**ANGEL PLACE
LEVEL 8, 123 PITT STREET
SYDNEY NSW 2000**

PITT STREET NORTH OSD REQUEST FOR ADDITIONAL INFORMATION STAGE 1 MODIFICATION (SSD 8875 MOD 1) & STAGE 2 (SSD 10375)

This letter responds to the request for additional information dated 4 February 2021 in relation to the above applications for the Pitt Street North Over Station Development (OSD).

4.5 Modified Envelope
Envelope Protusions - Typical Tower levels

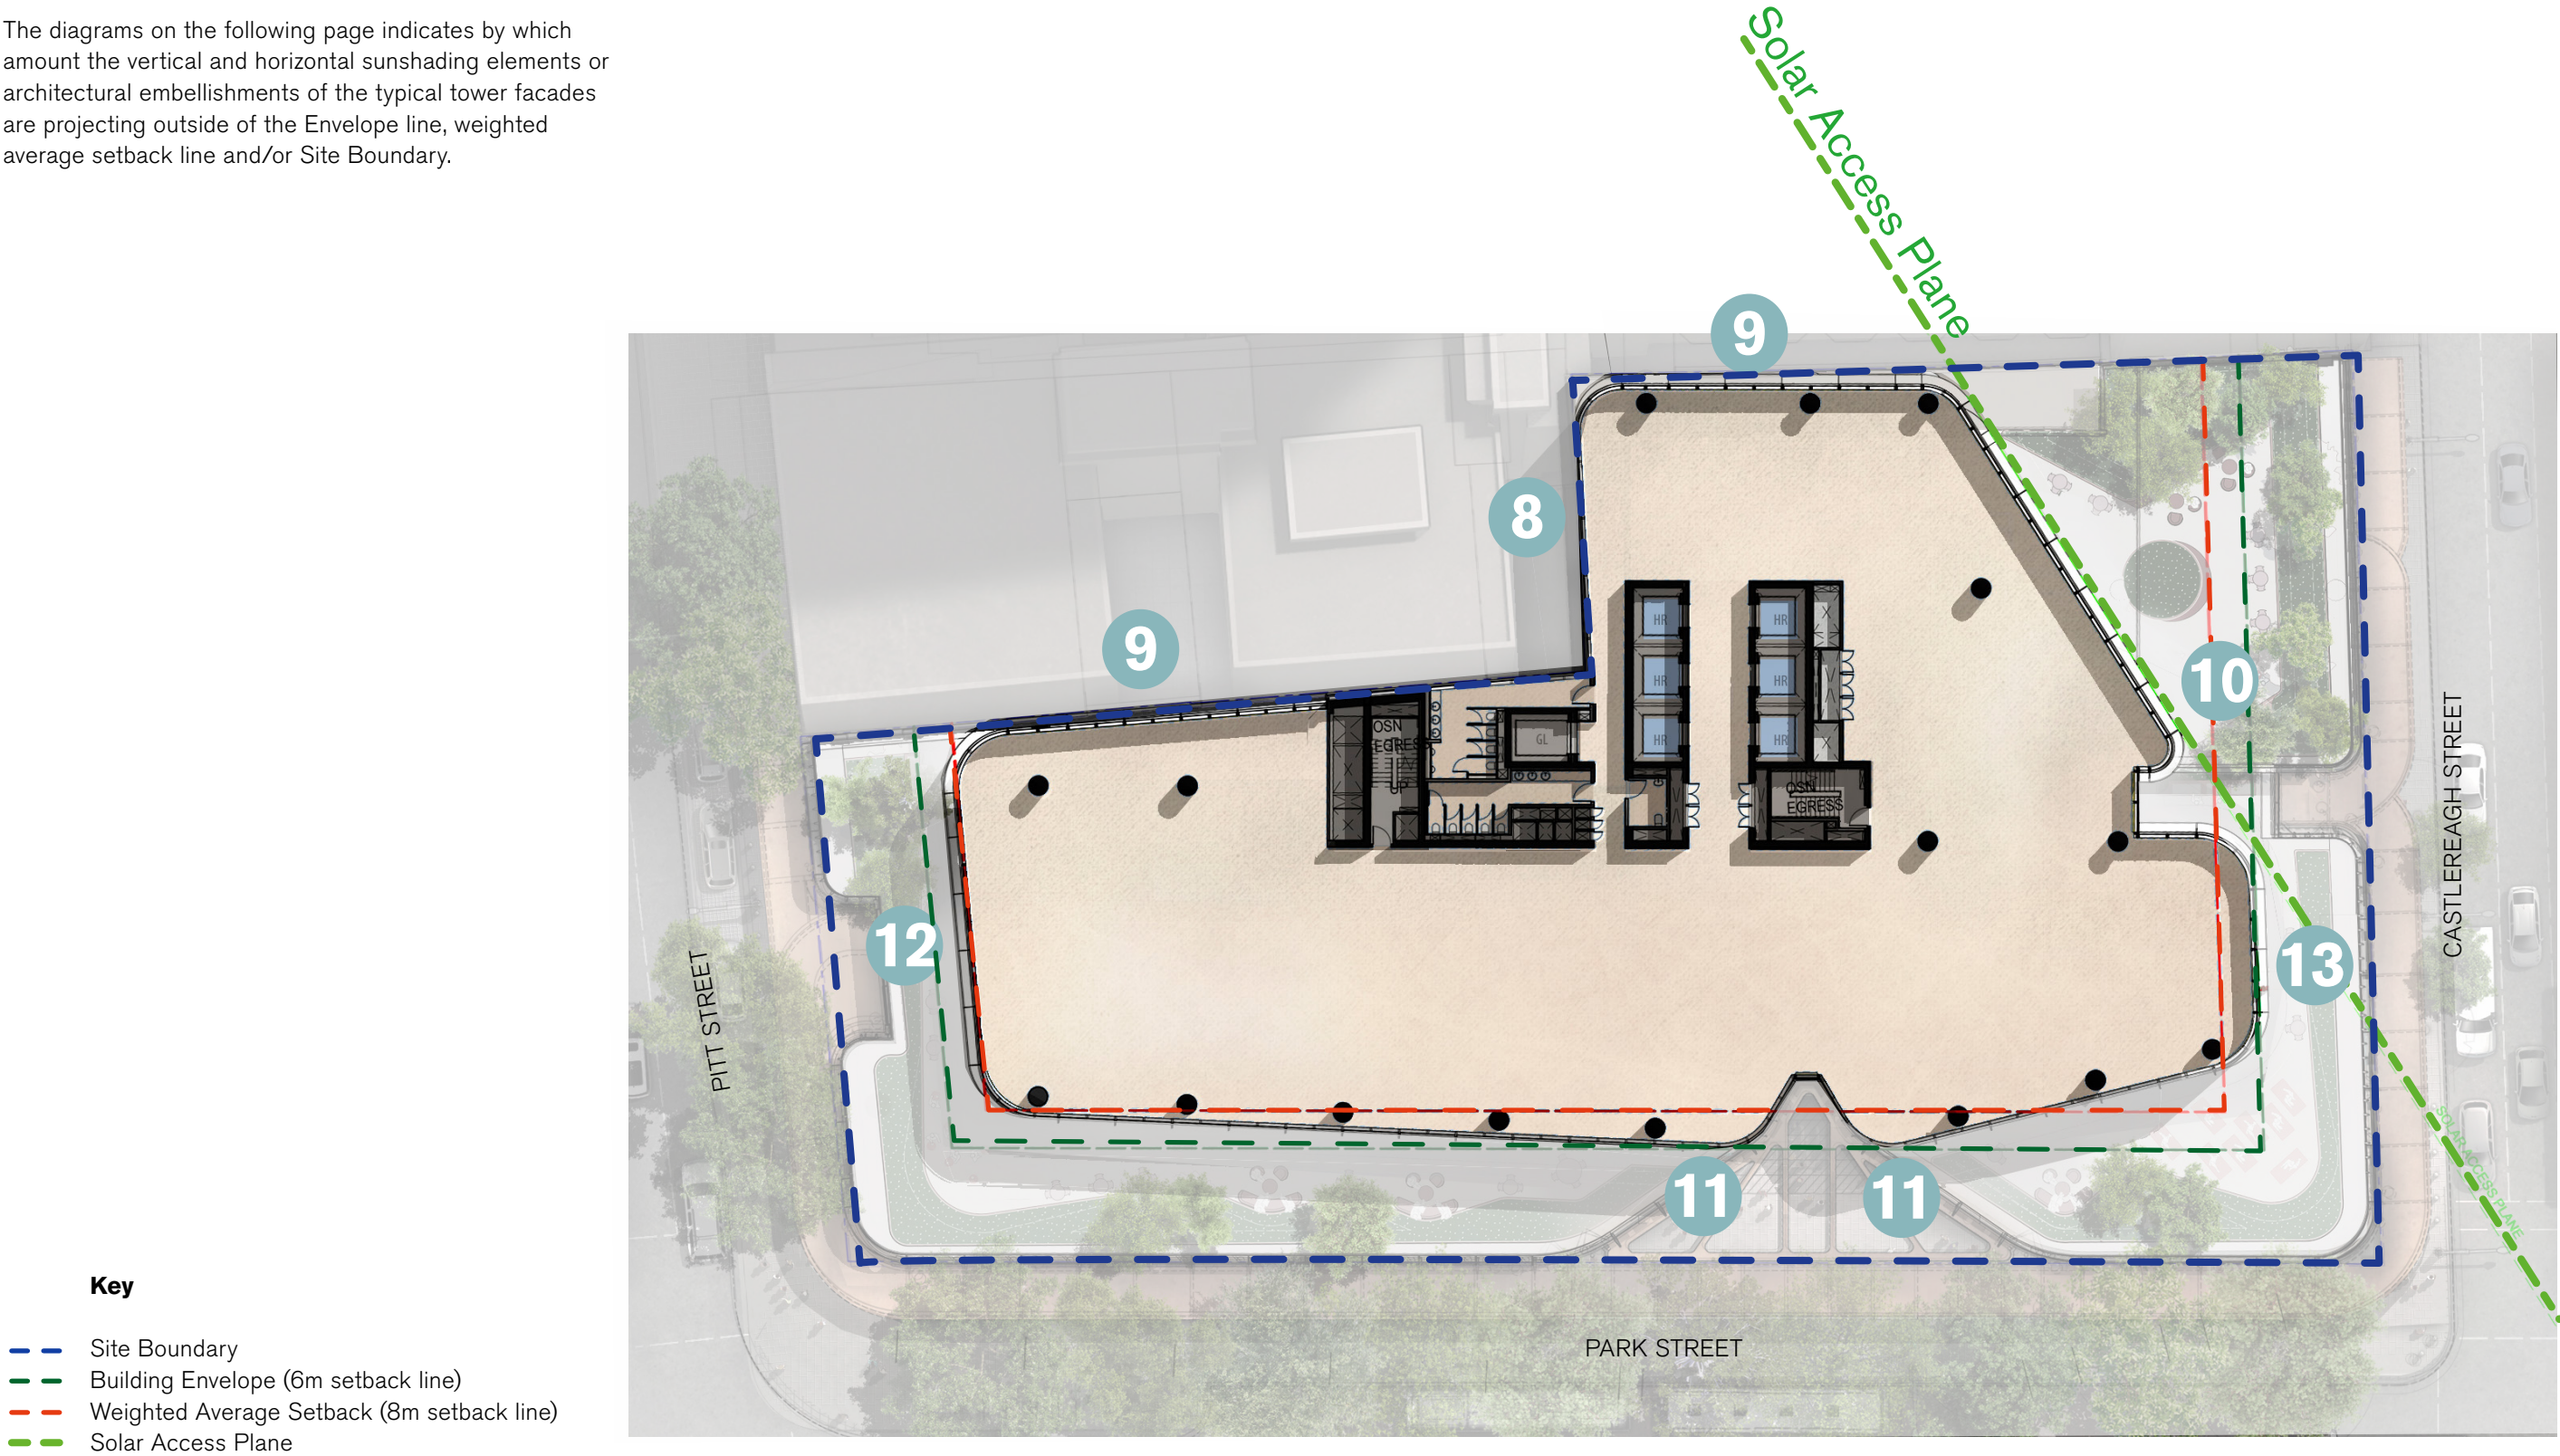
“Clarify the extent of the proposed projections beyond the approved building envelope. In particular, the extent (if any) of the proposed sunshades on the tower encroaching on the required minimum 6 metre setback along Castlereagh Street.”

Figure 1 and **Figure 2**, illustrates the proposed tower sun shading projections in relation to the building envelope (6m setback line), weighted average setback and site boundary. No building elements (including sun shading devices) project beyond the solar access plane.
